# H2Teesside Project

Planning Inspectorate Reference: EN070009

Document Reference: 9.7: Statement of Common Ground between H2 Teesside Limited and Natural England

Date: February 2025

Plate 8B-1: Windroses for Durham Tees Valley Airport Meteorological Station, 2018 to 2022

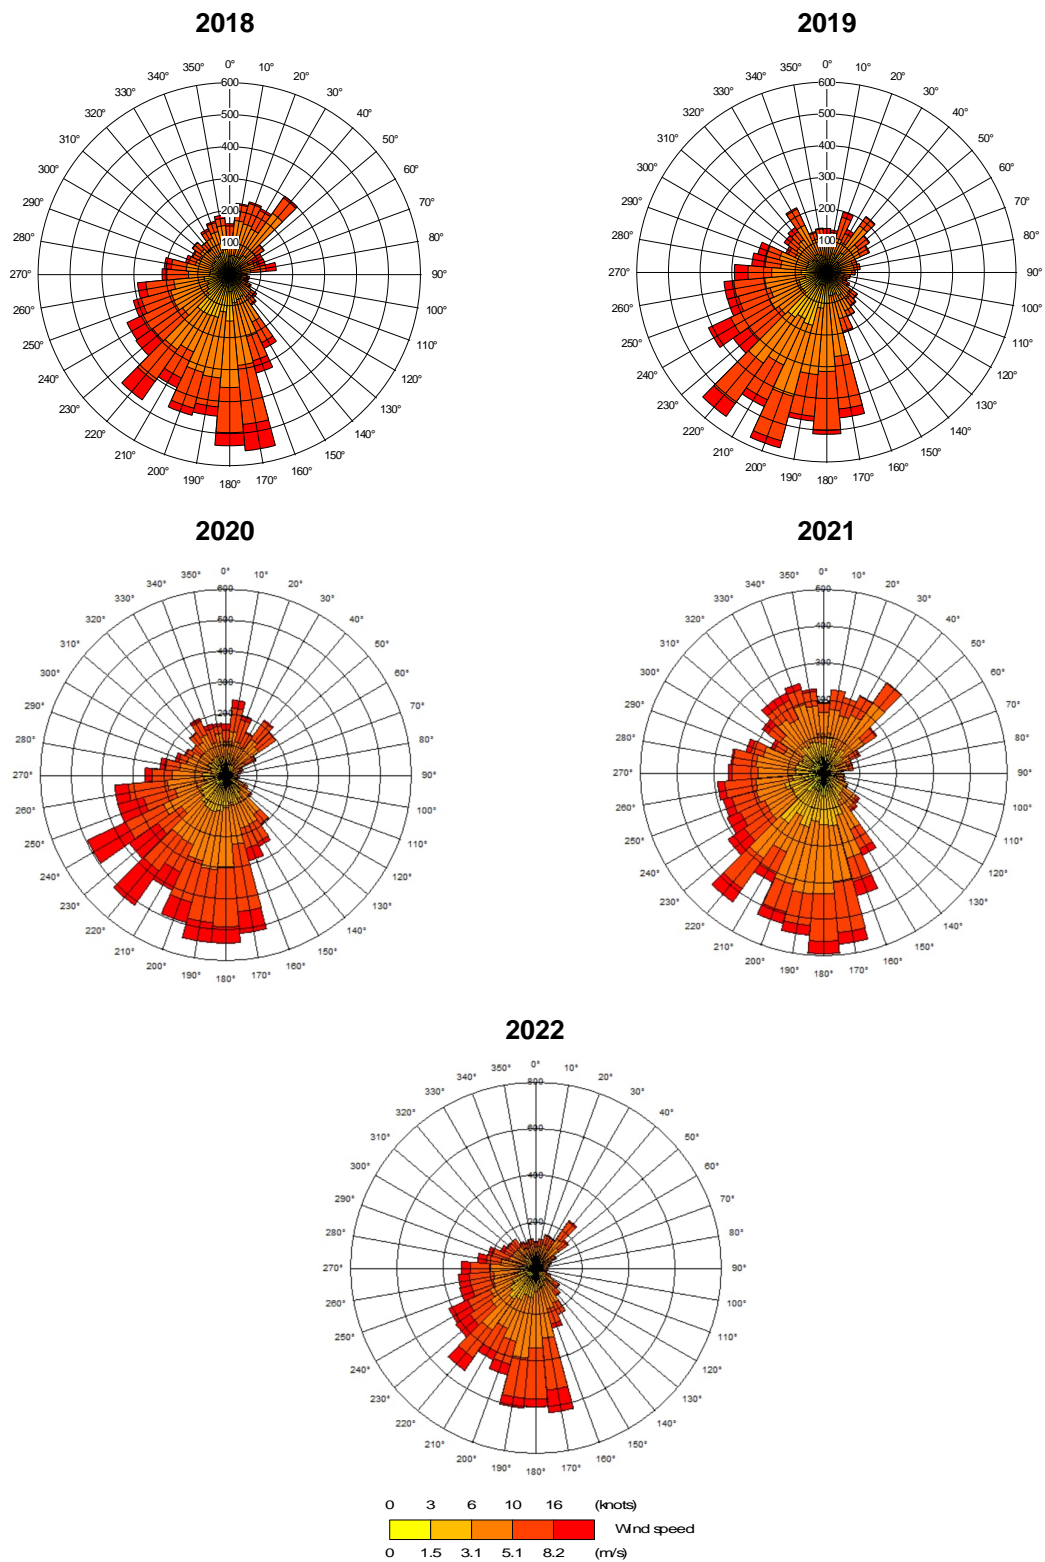
6.	ES Appendix 8B and the HRA	NE31	<p>ES Appendix 8B [APP-191] shows that in combination acid deposition at Hart Bog SSSI is 0.005 keq which is over 1% of the critical load, and PEC is exceeded. However, the contribution of H2Teesside is 0.000 i.e. effectively zero at the distance at which Hart Bog is situated.</p> <p>With regard to the Teesmouth and Cleveland Coast SSSI, paragraph 12.6.16 shows that 'in combination' nitrogen deposition is forecast to be 13.89 kgN/ha/yr, whereas N deposition in 2003 was up to 14.77 kgN/ha/yr. Therefore, a net improvement in nitrogen deposition is forecast and nitrogen deposition rates are forecast to be materially lower than they were when the habitat in question established. While the dune system is not 'new', the habitat structure has extensively changed due to slag deposition and movement from at least the 1940s to the early 2000s. In these decades N deposition will have been higher than it is now due to much higher NOx emissions (and was certainly higher in 2003 than it is now according to APIS). For example, UK N deposition</p>	<p>NE has raised specific issues in relation to Appendix 8B [APP-191] and the HRA, as follows:</p> <ul style="list-style-type: none"> <li>• Acid deposition exceeded 1% of the acid critical load at Hart Bog SSSI so should be considered. (Table 8B-43).</li> <li>• Natural England do not agree with the statement in section 12.6.16 of the HRA</li> </ul> <p>NE do not therefore consider that the assessment demonstrates no damage to Teesmouth and Cleveland Coast SSSI.</p> <p>D2 update: It is accepted that the contribution from the Proposed Development may be negligible but the argument needs to be made in the Report to Inform HRA.</p> <p>The comments on Ndep at the SSSI are the same as for NE17, the site is still exceeding its critical load and the Proposed Development is adding to this. The Applicant needs to justify that the Proposed Development would not undermine</p>

SOCG ID	MATTER	REPRESENTATION REFERENCES	APPLICANT POSITION	NATURAL ENGLAND POSITION
			<p>reduced from 465 kt N in 1990 to 278 kt N in 2017 (Tomlinson et al, 2021).</p> <p>This position was submitted into the Examination for the consented Net Zero Teesside DCO and enabled no likely significant effects to be reported for this site by that applicant. That was subsequently accepted by the Examining Authority/Secretary of State for that DCO, and it would be inconsistent to take a different approach for the Proposed Development.</p> <p>D3 update: The Report to Inform HRA has been amended as part of the Proposed Change Application, the Change Application Report concludes no likely significant effect will arise on Teesmouth &amp; Cleveland SSSI based on the negligible contribution of the Proposed Development.</p> <p>D5 update: With regard to impacts on the SSSI, the Applicant had meetings with Natural England on 28th November and 4th December. At those meetings the Applicant clarified that the dunes at Teesmouth &amp; Cleveland Coast SSSI are calcareous</p>	<p>any environmental improvement that has occurred in recent years.</p> <p>D4 update: Natural England have requested clarification on cumulative nitrogen sources and confirmation that even minor increases will not hinder habitat recovery efforts within the SPA/SSSI.</p> <p>D5 update: It is noted that the qualifying features for the SPA are not the same as the SSSI designated features. Therefore, even if the justification that the nesting bird species would not be adversely affected by changes to their supporting habitat within the SPA is appropriate to demonstrate no AEOI to the SPA, consideration must also be given (outside the HRA) to any harm to the SSSI designation. This can take into account the potentially lesser sensitivity of calcareous dunes compared to acidic/ decalcified dunes (for example, by demonstrating phosphorus limitation in the dunes – as outlined in the report underlying the recent change in critical loads (Bobbink et al 2022 - Review and revision of empirical critical</p>
